**RESPONSES TO EXAMINING AUTHORITY'S
QUESTIONS 20/12/18**

**ON BEHALF OF THE
HISTORIC BUILDINGS AND MONUMENTS COMMISSION FOR ENGLAND
(HISTORIC ENGLAND)
("HBMCE")**

**Application by
Highways England for an Order granting Development Consent for the A303
Sparkford to Ilchester Dualling**

PINS Reference No: SPIL-SP0005 & 2001-4933

A303 SPARKFORD TO ILCHESTER DUALLING
WORKS PLANS REGULATION 5(2)(J)
SHEET 2 OF 4

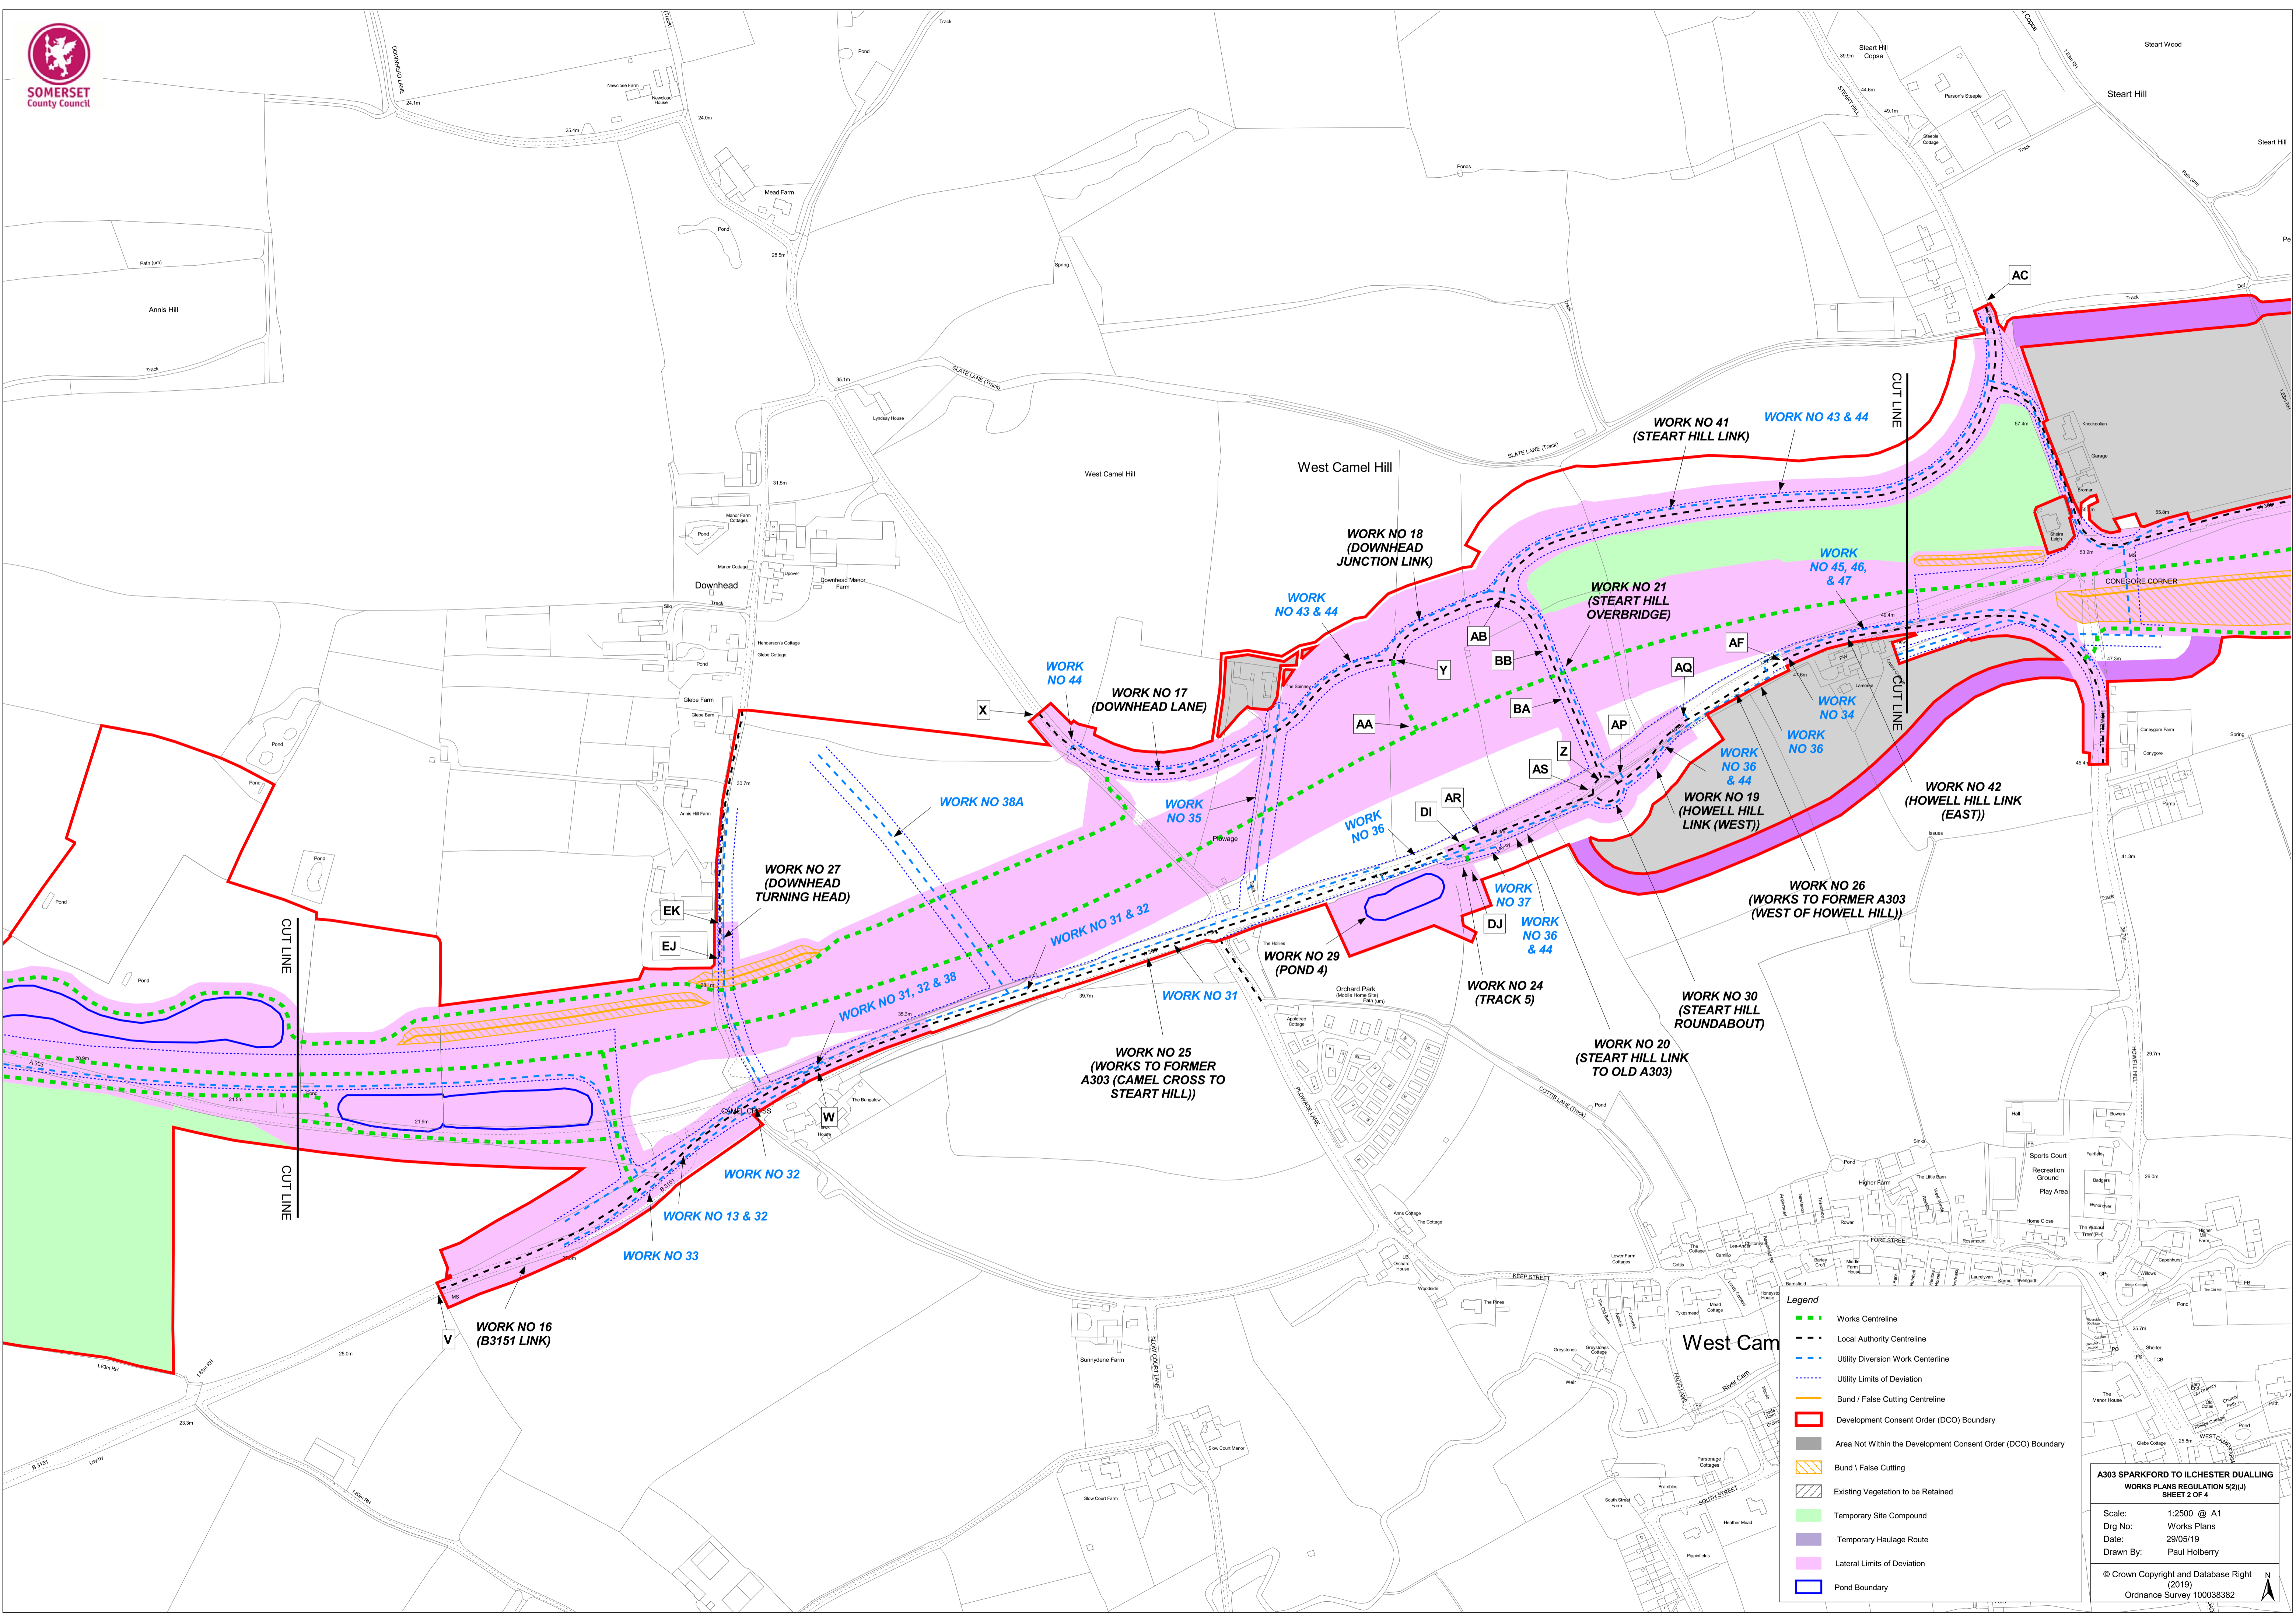
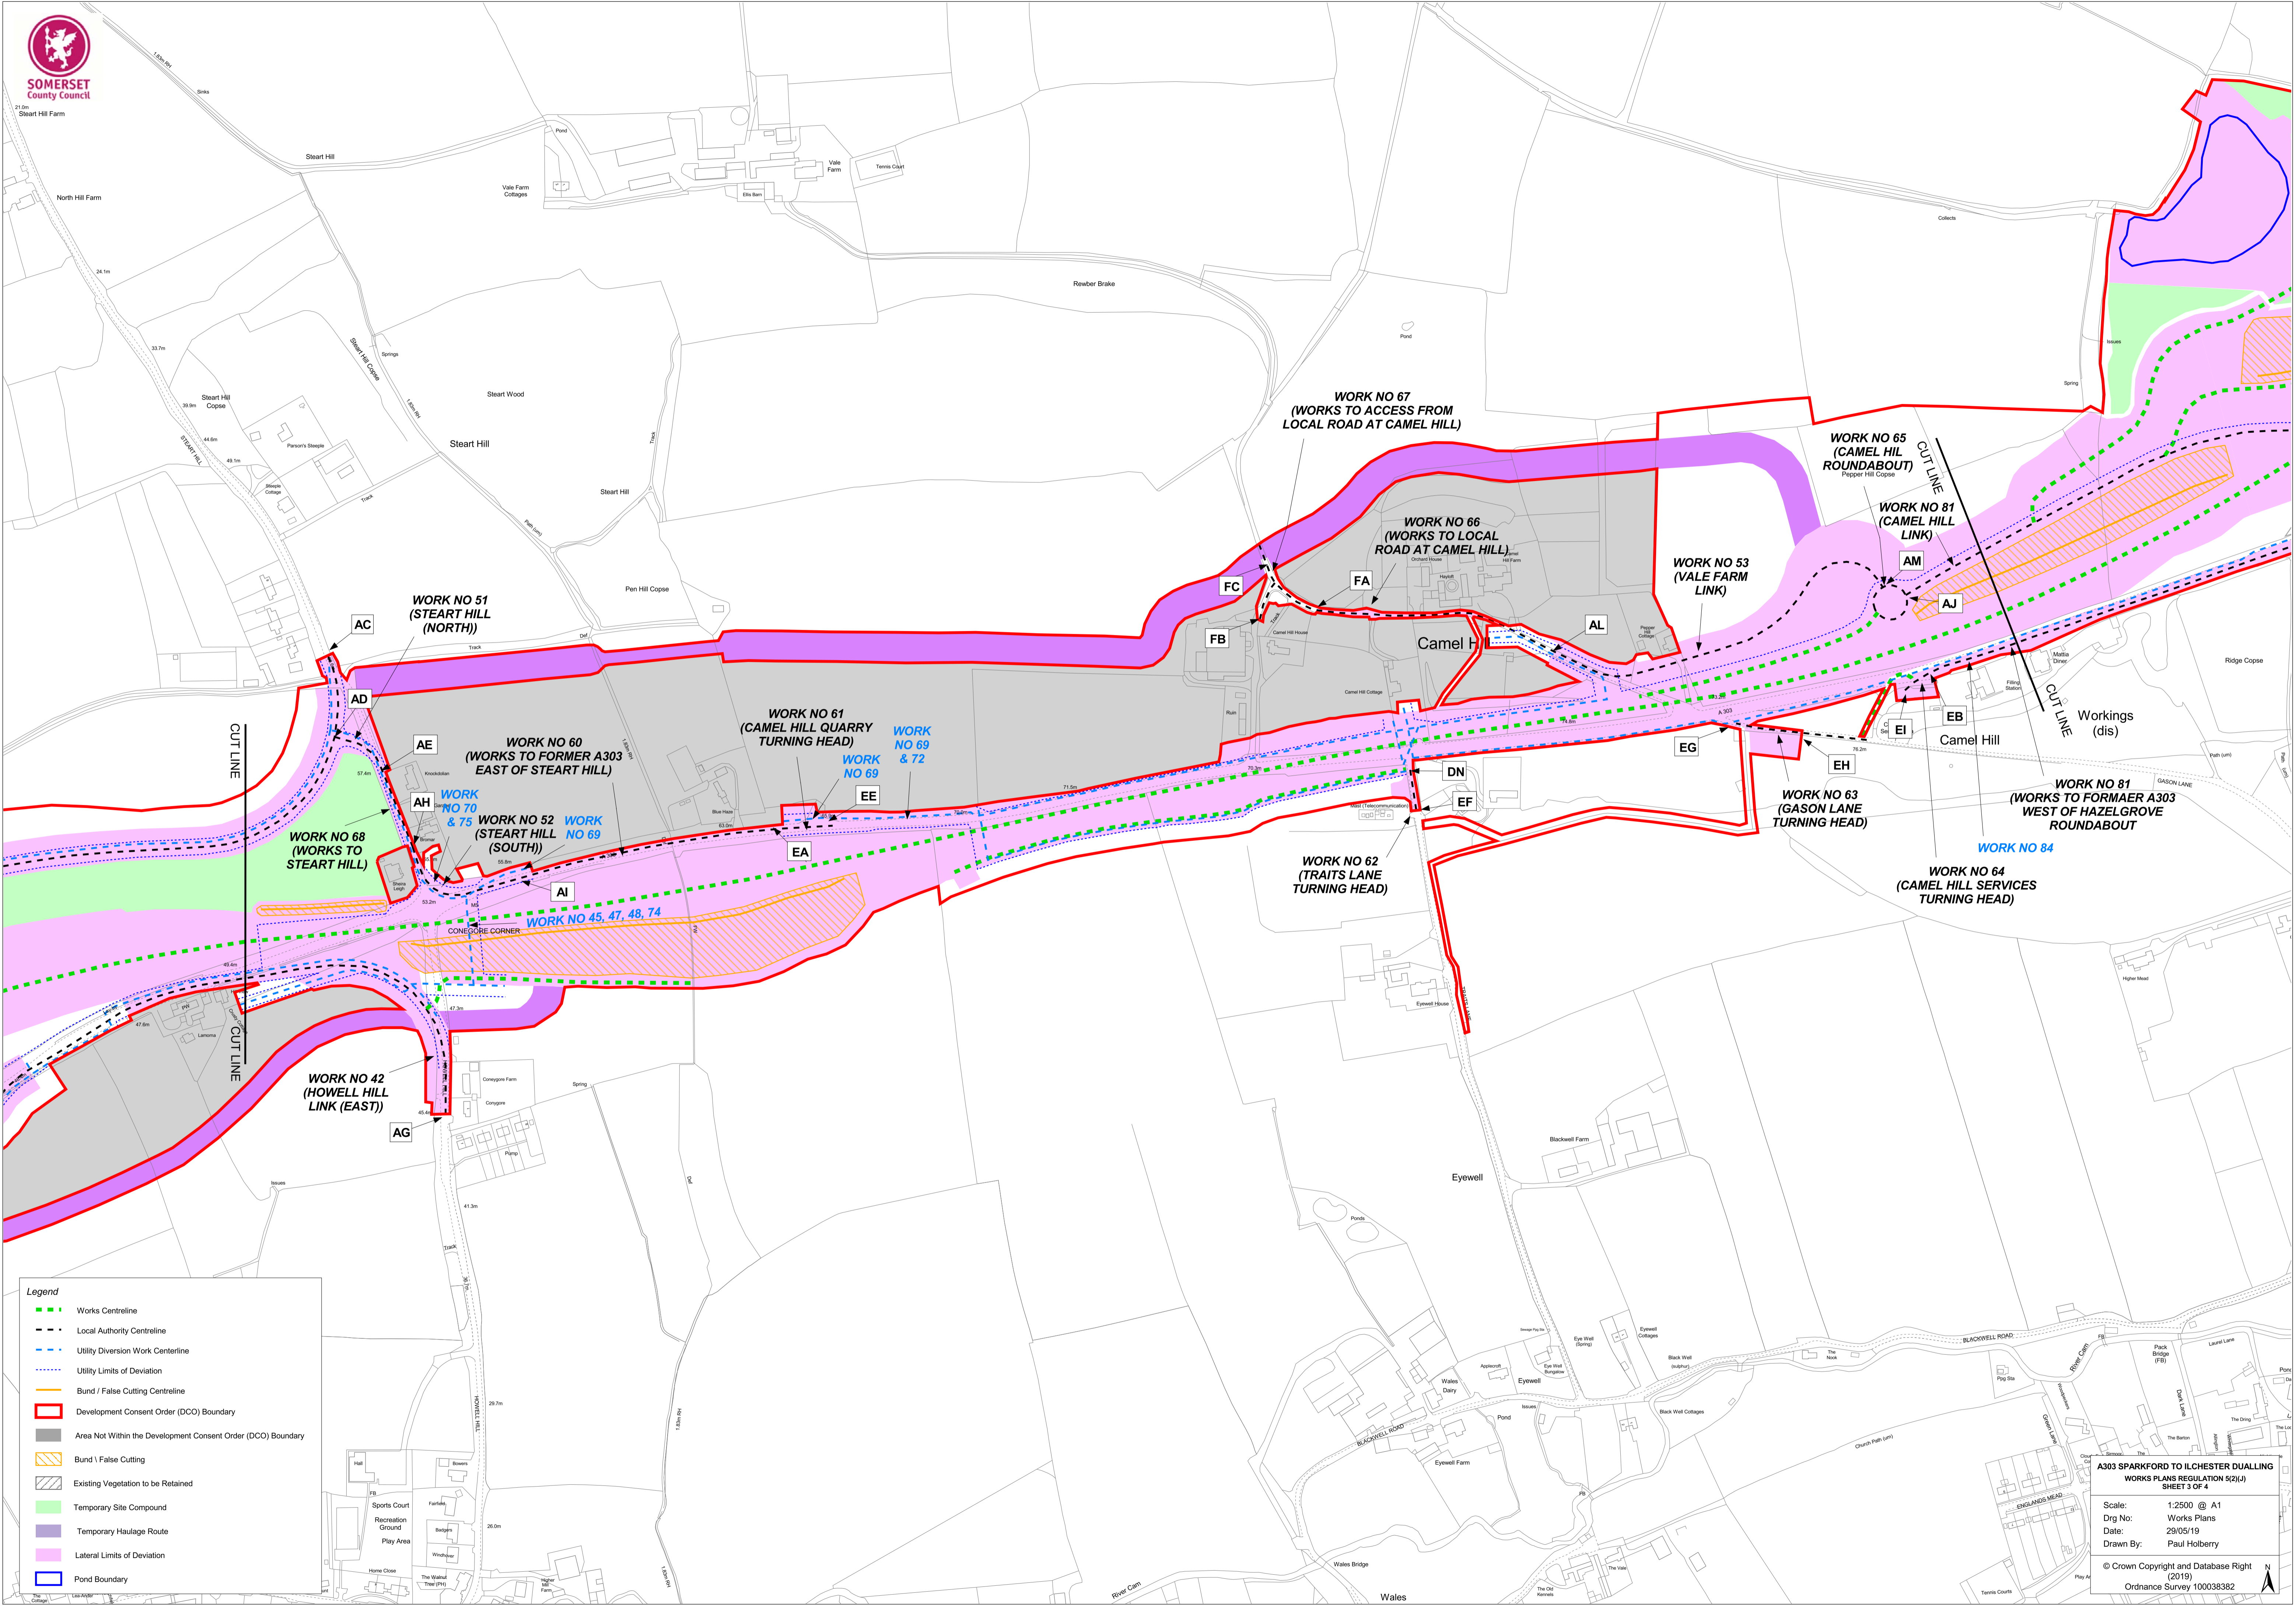
Can Historic England confirm which bund(s) as shown on the Works Plan [APP-006] it is referring to?

HBMCE response: Bunds 5, 6 and 7 (Work no.s 82, 89 and 90 respectively). Refer also to HBMCE Written Representation Section 7.5.3 (e) where the impact of the bunds in terms of screening is considered.
